Rezoning Transportation Analysis

Petition Number: 2019-173

Revision Log:

Date	Description
01-17-2020	First Review
05-20-2020	Second Review (WB)

SECTION A - A
PROPOSED ROAD IMPROVEMENTS
(FUTURE BY OTHERS)

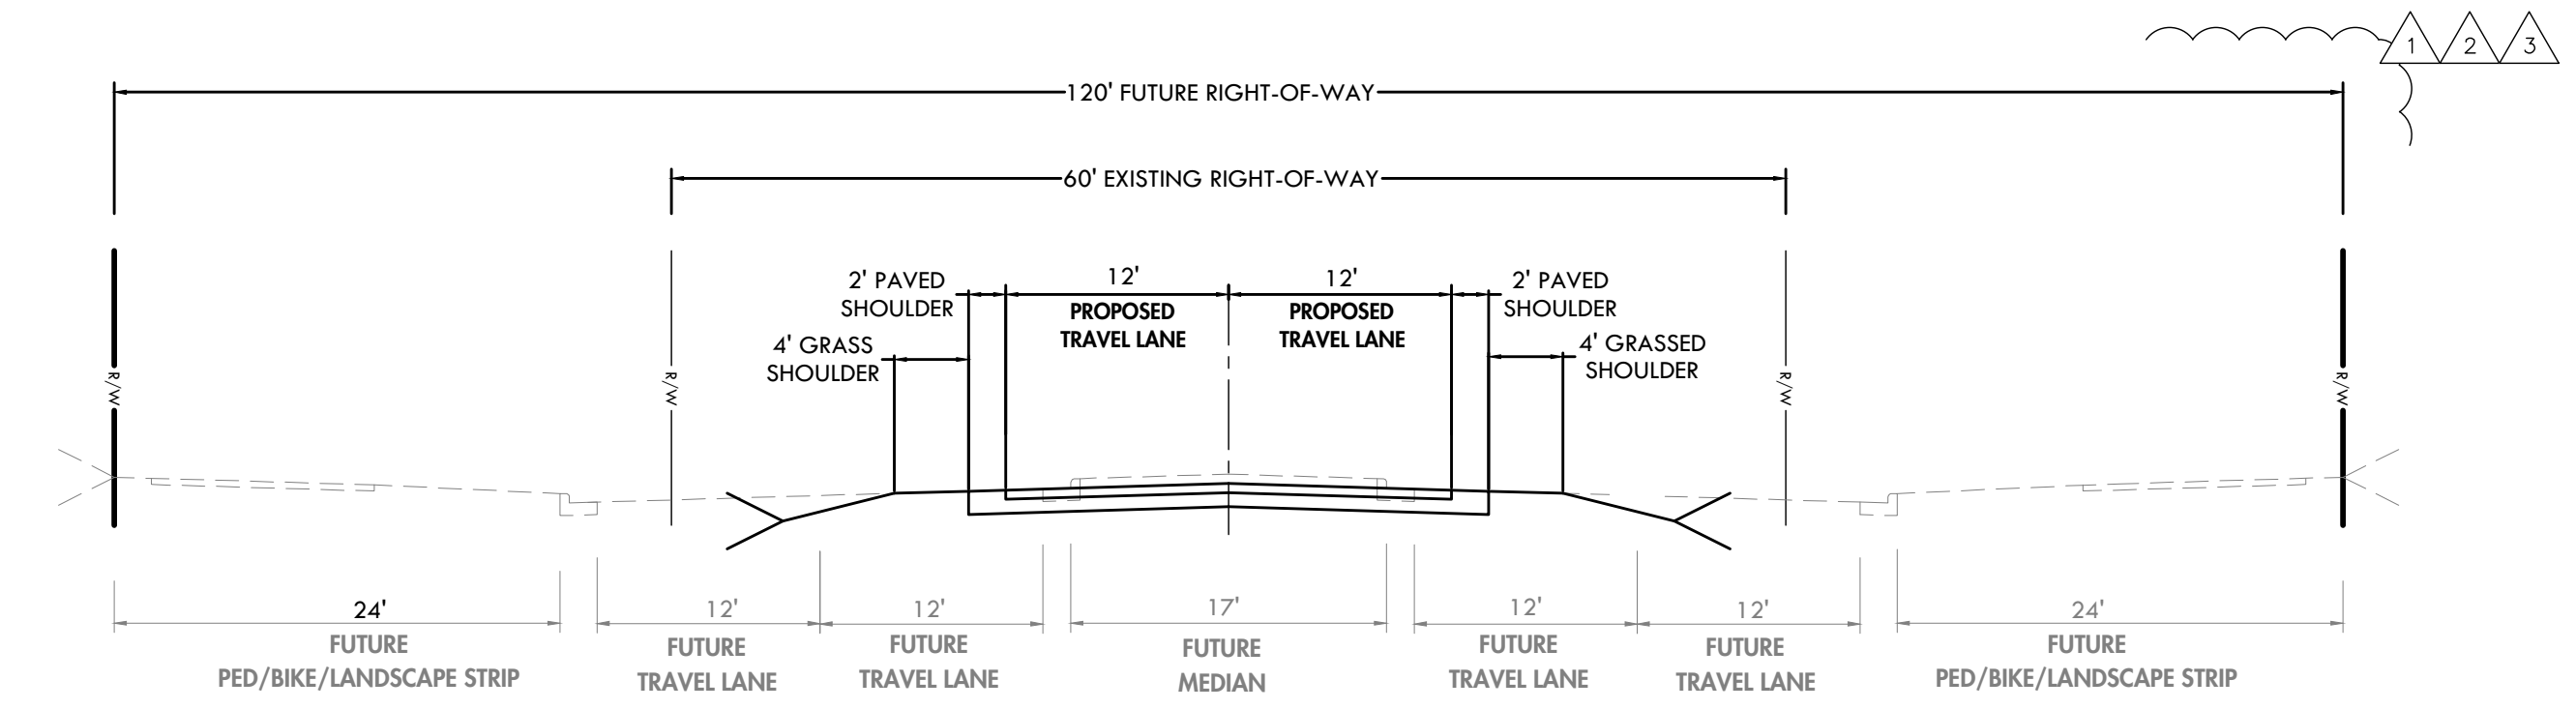
6. **New Comment based on revised site plan 05-11-2020:** The petitioner should revise the site plan and conditional notes to commit to construct 2-12' lanes with 2' paved shoulders and 4' grass shoulders. for Section A-A. The petitioner should add a note stating the final details will be determined during permit review process to include input from other departments including but not limited to CDOT, General Services, Charlotte Fire Department, the NCDOT. Also include that any applicable ordinance requirements in addition to what is shown on proposed cross-sections may be required

SECTION B - B
PROPOSED ROAD IMPROVEMENTS
(FUTURE BY OTHERS)

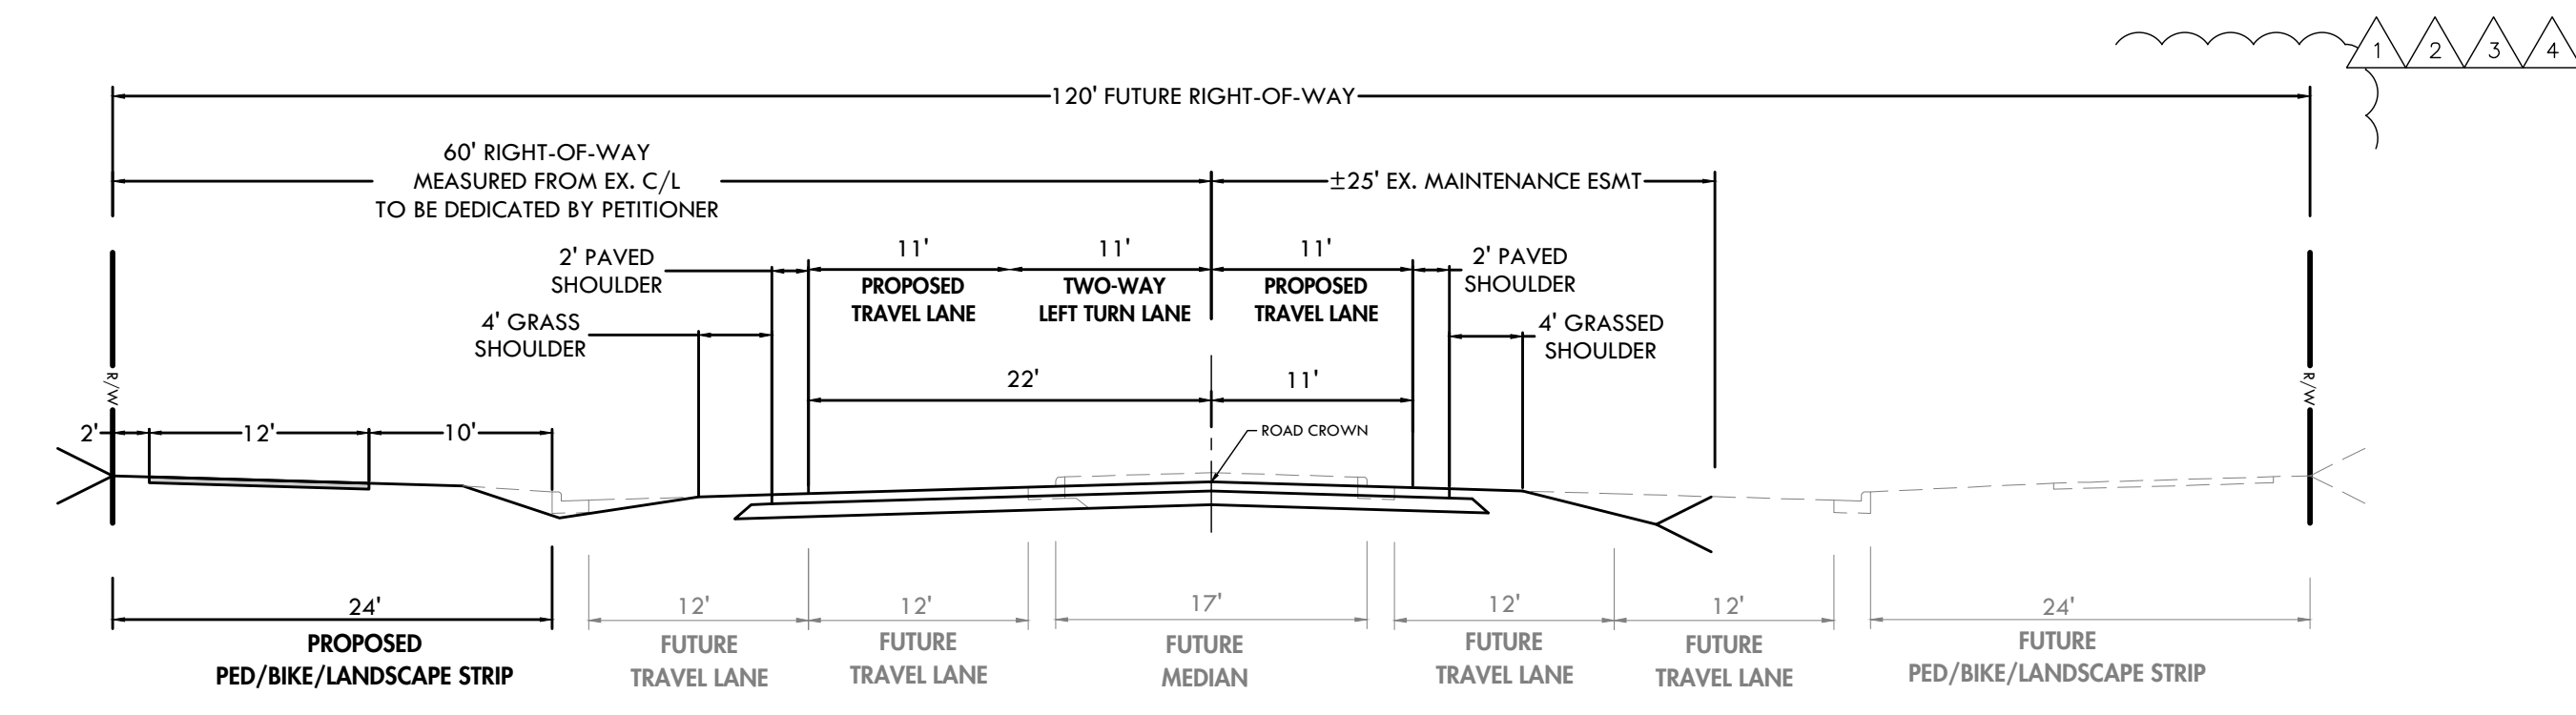
- New Comment based on revised site plan 05-11-2020:** The petitioner should revise the site plan and conditional notes to commit to construct 2-12' lanes with 2' paved shoulders and 4' grass shoulders for Section B-B. The petitioner should add a note stating the final details will be determined during permit review process to include input from other departments including but not limited to CDOT, General Services, Charlotte Fire Department, the NCDOT. Also include that any applicable ordinance requirements in addition to what is shown on proposed cross-sections may be required

SECTION C - C
PROPOSED ROAD IMPROVEMENTS
(FUTURE BY OTHERS)

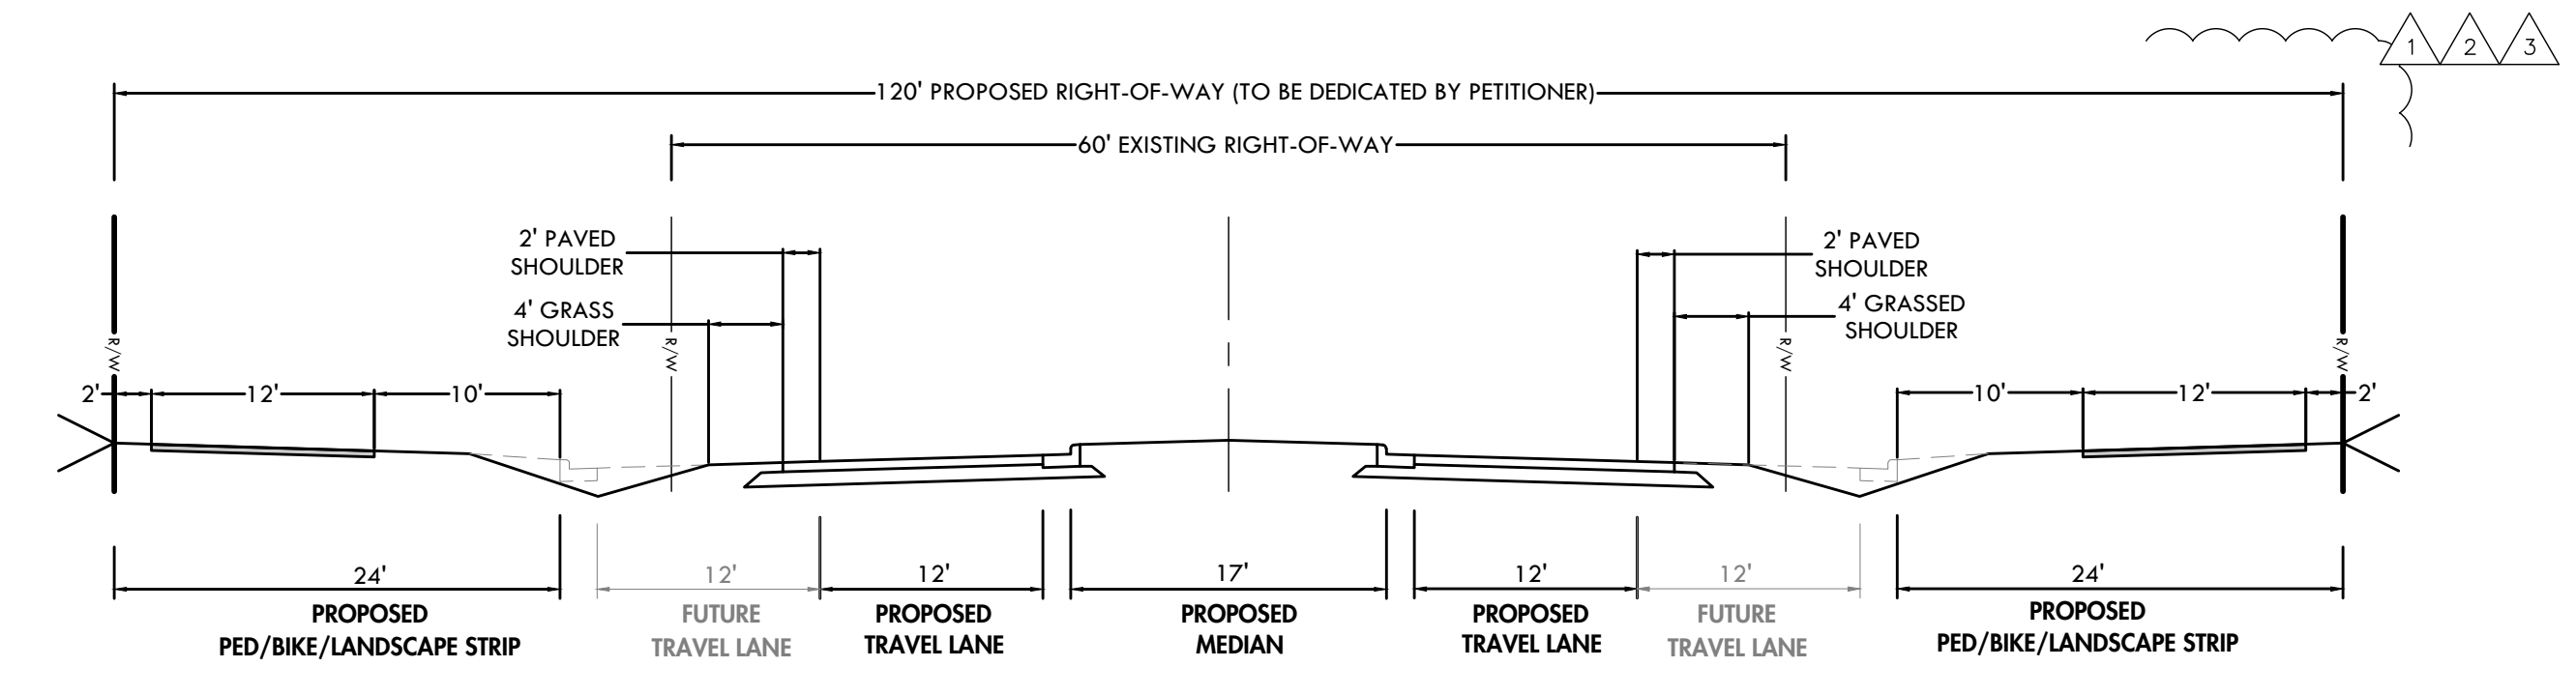
- New Comment based on revised site plan 05-11-2020:** Cross-section C-C depict the general intent of a 3-lane section (2 travel lanes and center turn lane and/or planted median) and a shared-use path for an interim version of future Garrison Road. The petitioner should revise the site plan and conditional notes to commit to construct 2' paved shoulders and 4' grass shoulders. The petitioner should add a note stating the final details will be determined during permit review process to include input from other departments including but not limited to CDOT, General Services, Charlotte Fire Department, the NCDOT. Also include that any applicable ordinance requirements in addition to what is shown on proposed cross-sections may be required.
